Rezoning Transportation Analysis

Petition Number: 2022-130

Date	Description
12-28-22	First Review (IW)

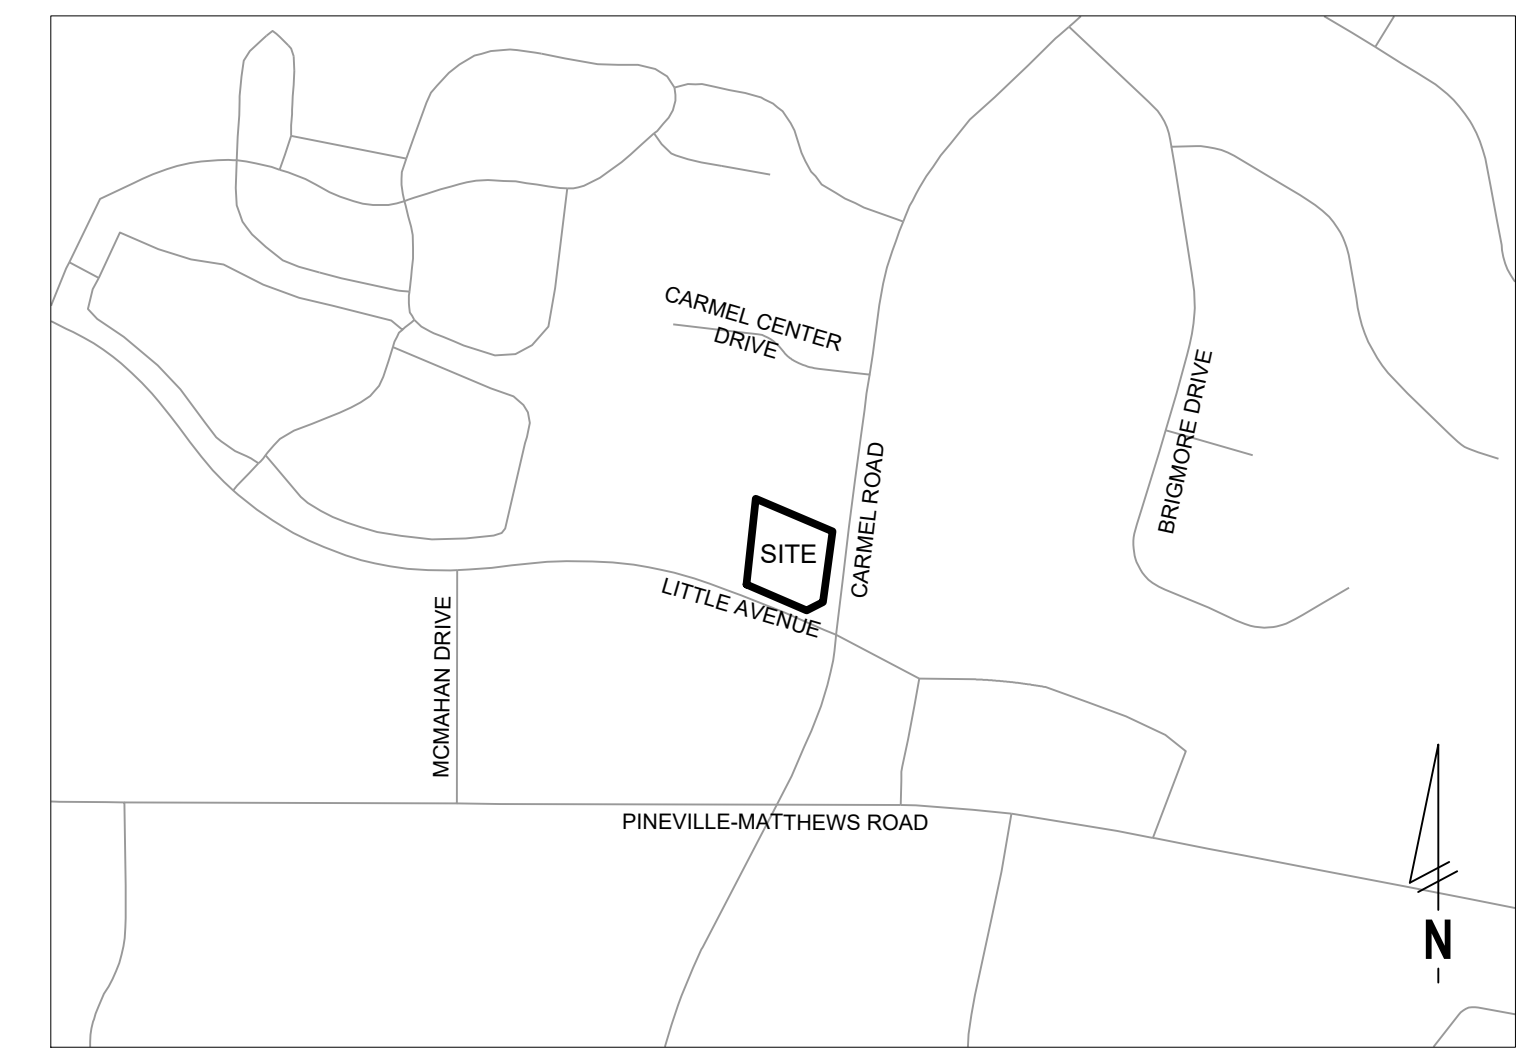
- a. **Carmel Road:** Location of back of curb and gutter to be moved to 33 feet from roadway centerline to accommodate the Charlotte Streets Map with a roadway typical section of CLDSM 11.09 Major Thoroughfare.
- b. **Little Avenue:** The future location of curb and gutter is in its existing location.

Label and dimension the curb and gutter from the centerline for each road on the site plan.

3. Revise site plan and conditional note(s) to commit to dedicate 55' right-of-way from the road centerline on Carmel Road. The site plan shall label and dimension the right-of-way from the road centerline.

4. Revise site plan and conditional note(s) to commit to construct an 8-foot planting strip, and 12-foot Multi-Use Path on Carmel Road per the council adopted Charlotte Streets Map. The site plan shall label and dimension both items from the back of curb and gutter or edge of pavement.

5. Revise site plan and conditional note(s) to commit to installing a 12' multi-use path to meet the Council-adopted Charlotte BIKES Policy on Carmel Road. Multi-use paths maintained by the City shall meet ADA/PROWAG requirements.
